City of Albuquerque

RE: REVISED DRAINAGE PLAN FOR BRUNACINI WAREHOUSE (E-17/D41X), ENGINEER'S
STAMP DATED APRIL 22, 1992

**RE: INDUSTRIAL AND MINE SUPPLY COMPANY, PHASE III BUILDING ADDITION,
MIDWAY BUSINESS PARK (E17-D41X). GRADING AND DRAINAGE PLAN FOR
SITE DEVELOPMENT PLAN FOR BUILDING PERMIT AND FOR BUILDING
PERMIT APPROVALS. ENGINEER'S STAMP DATED JANUARY 27, 2000.**

GRADING AND DRAINAGE PLAN

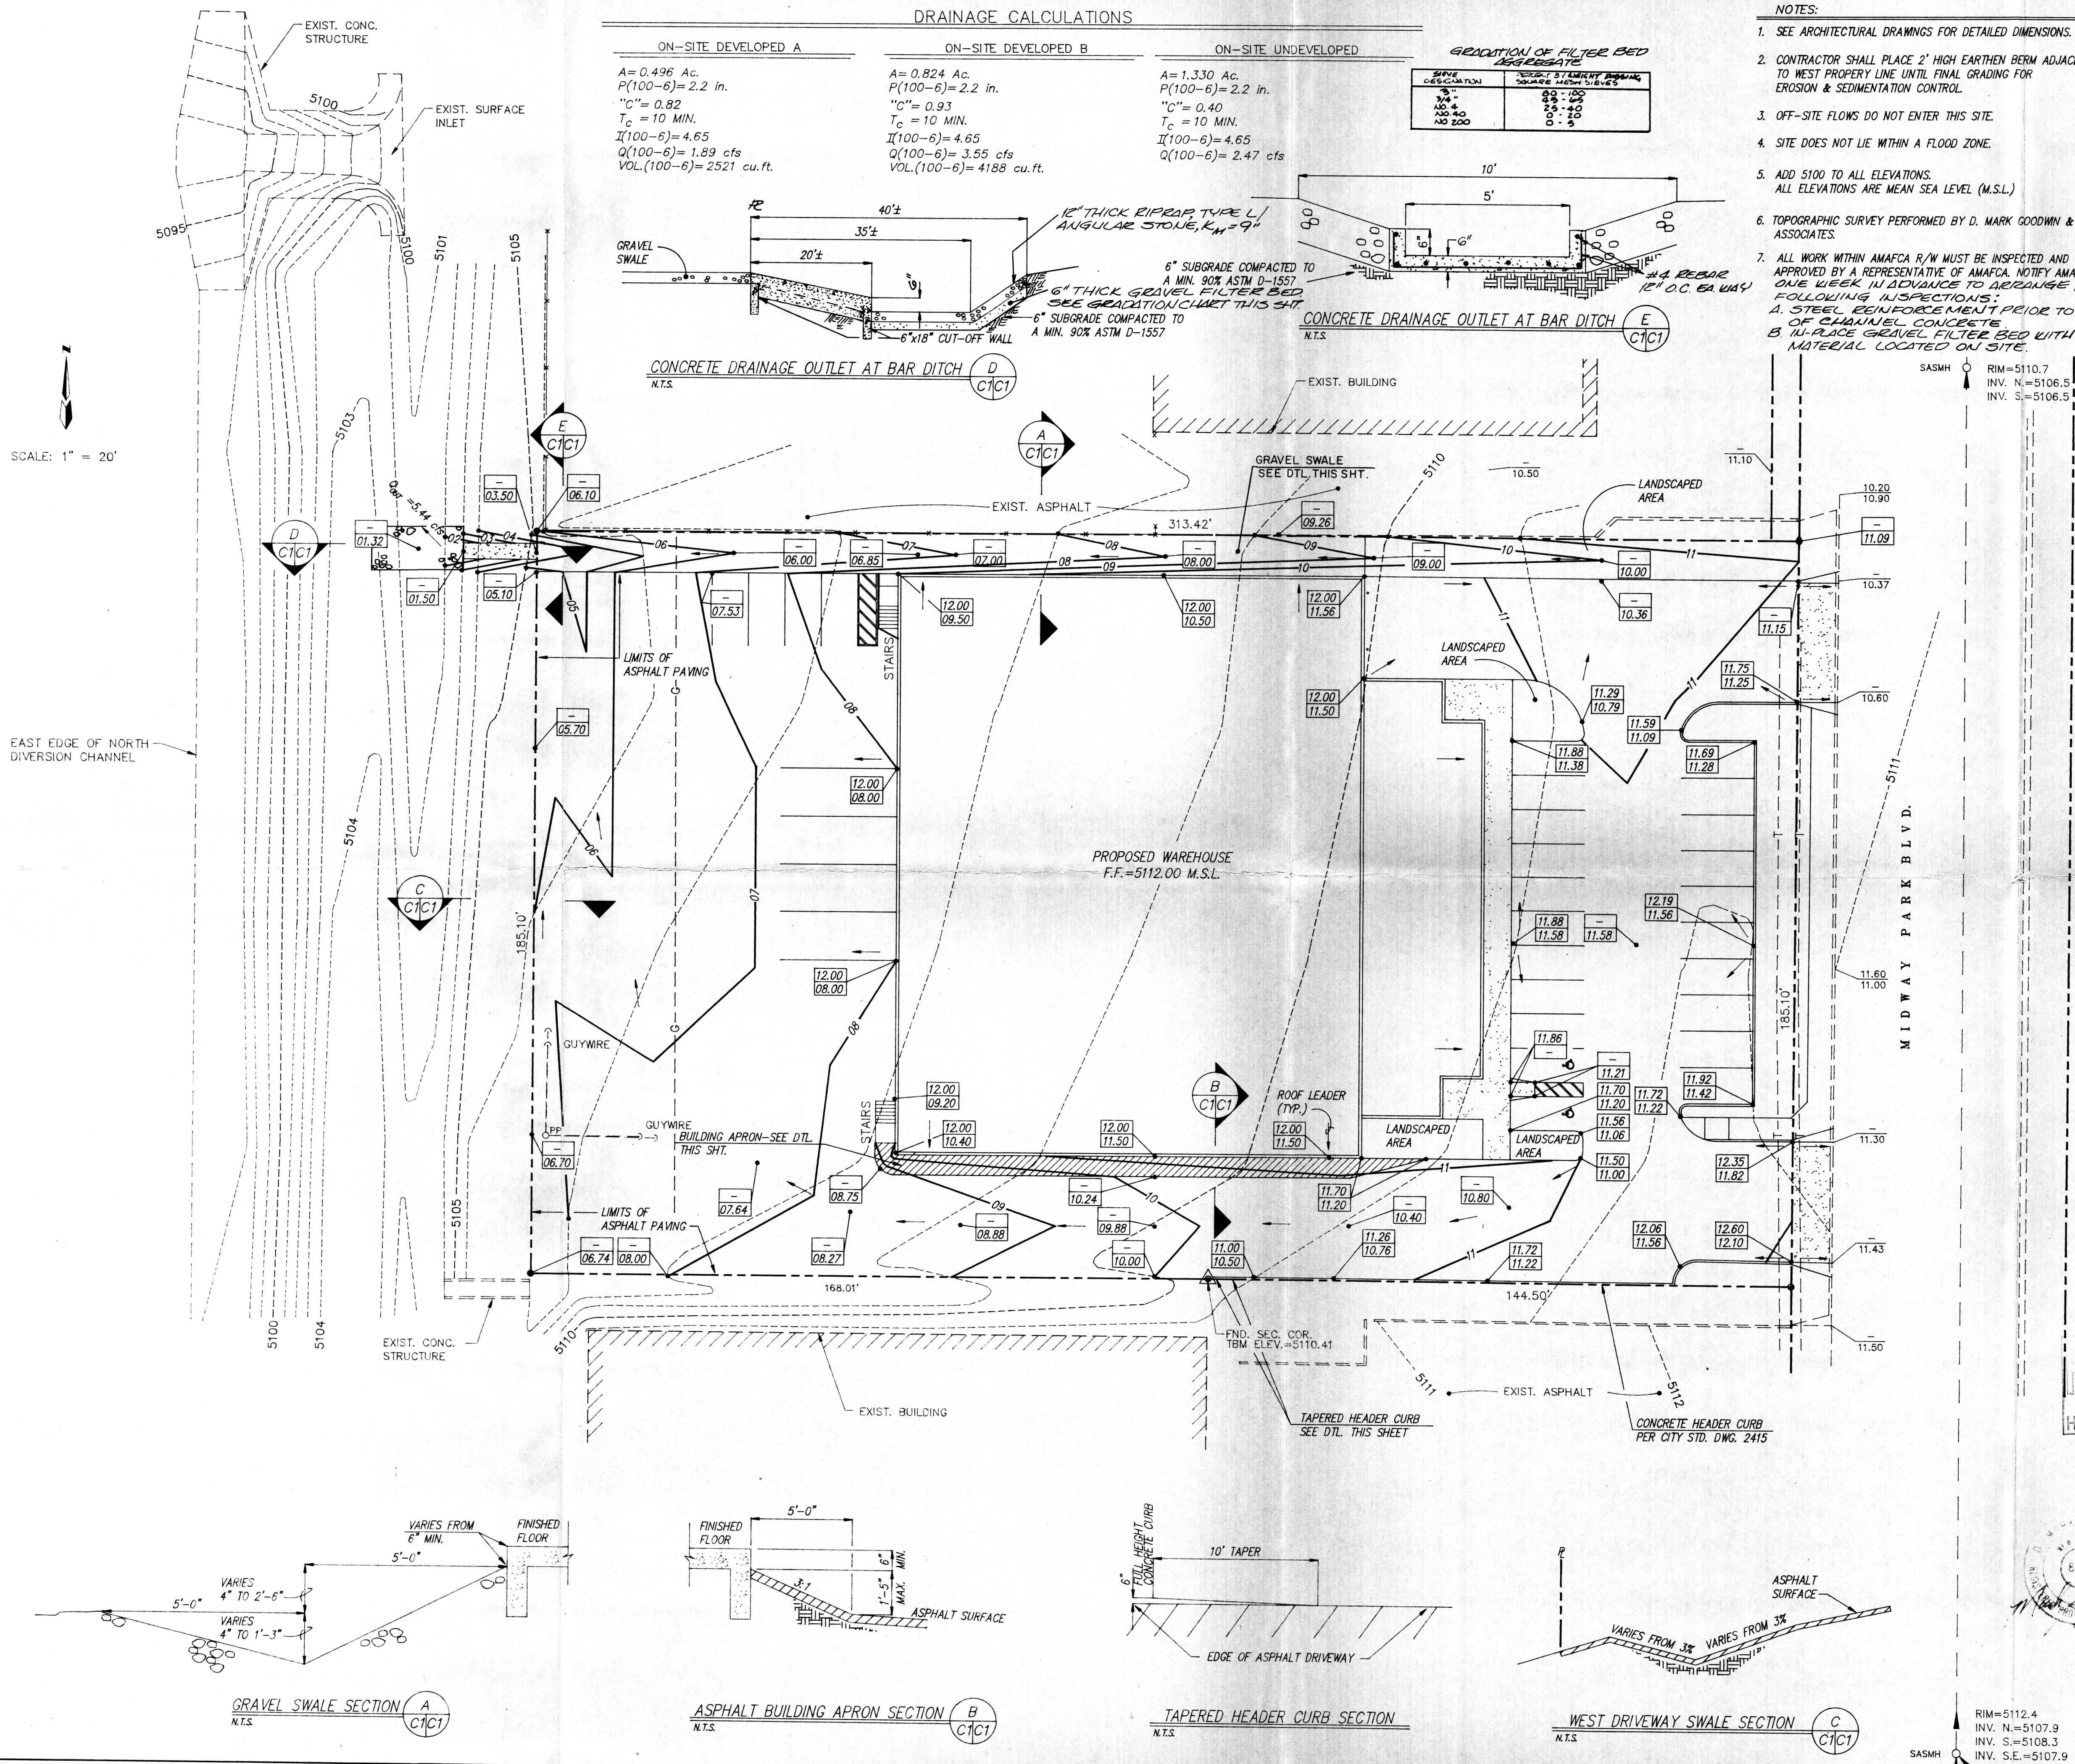
Please attach a copy of this approved plan to the construction sets prior to sign-off by Hydrology. Before doing so, however, add notation "existing" and "proposed" to building pads. Also state the Master Drainage Plan "Q" in the narrative.
